REPORT UPDATE

Application No: BR/341/10/

PLANNING APPLICATION REPORT

PROPOSAL: Outline application with some matters reserved for the demolition of derelict 2 storey office building & erection of 8 no. 2 bed flats & 6 no. 1 bed flats with ground floor parking, bin & cycle storage & childrens play area

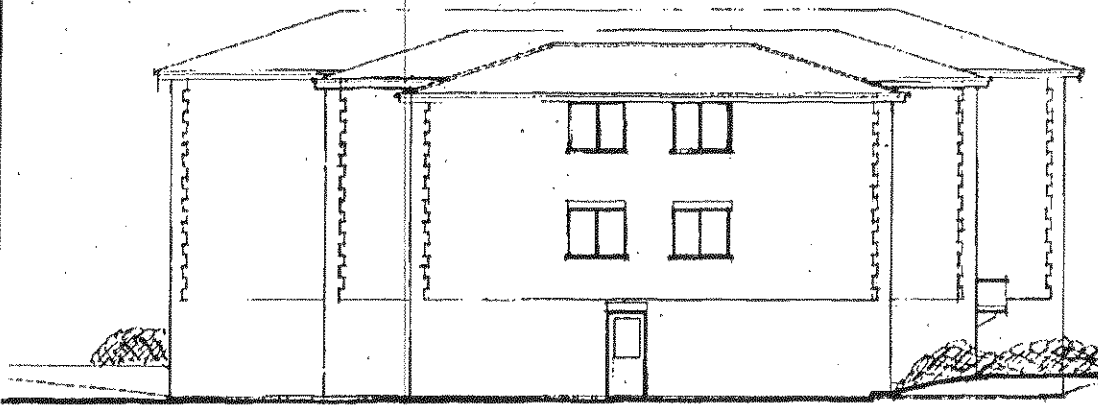
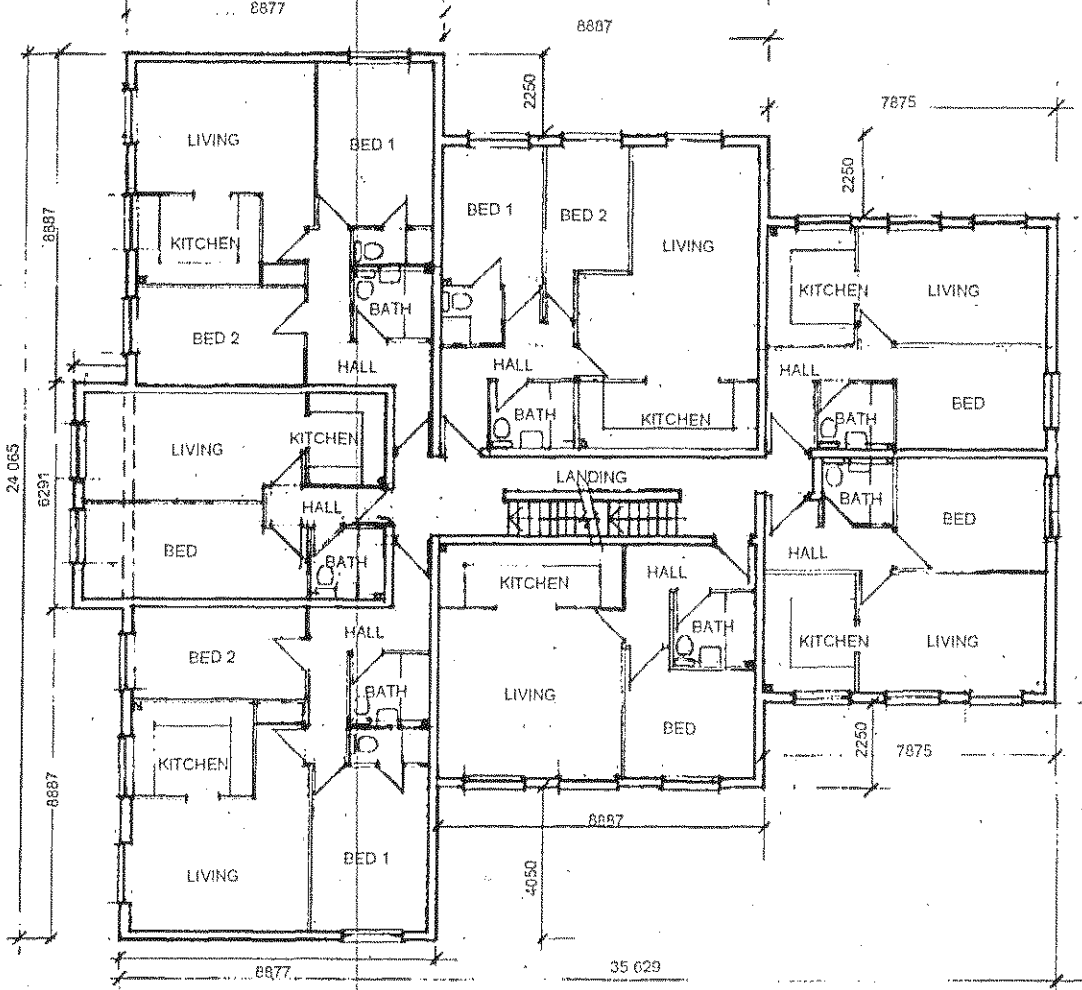
An additional informative is required to note the fact that the submitted indicative elevational plans show insufficient detail and information and that it is expected that adequate plans are submitted when a further application on scale and appearance is made.
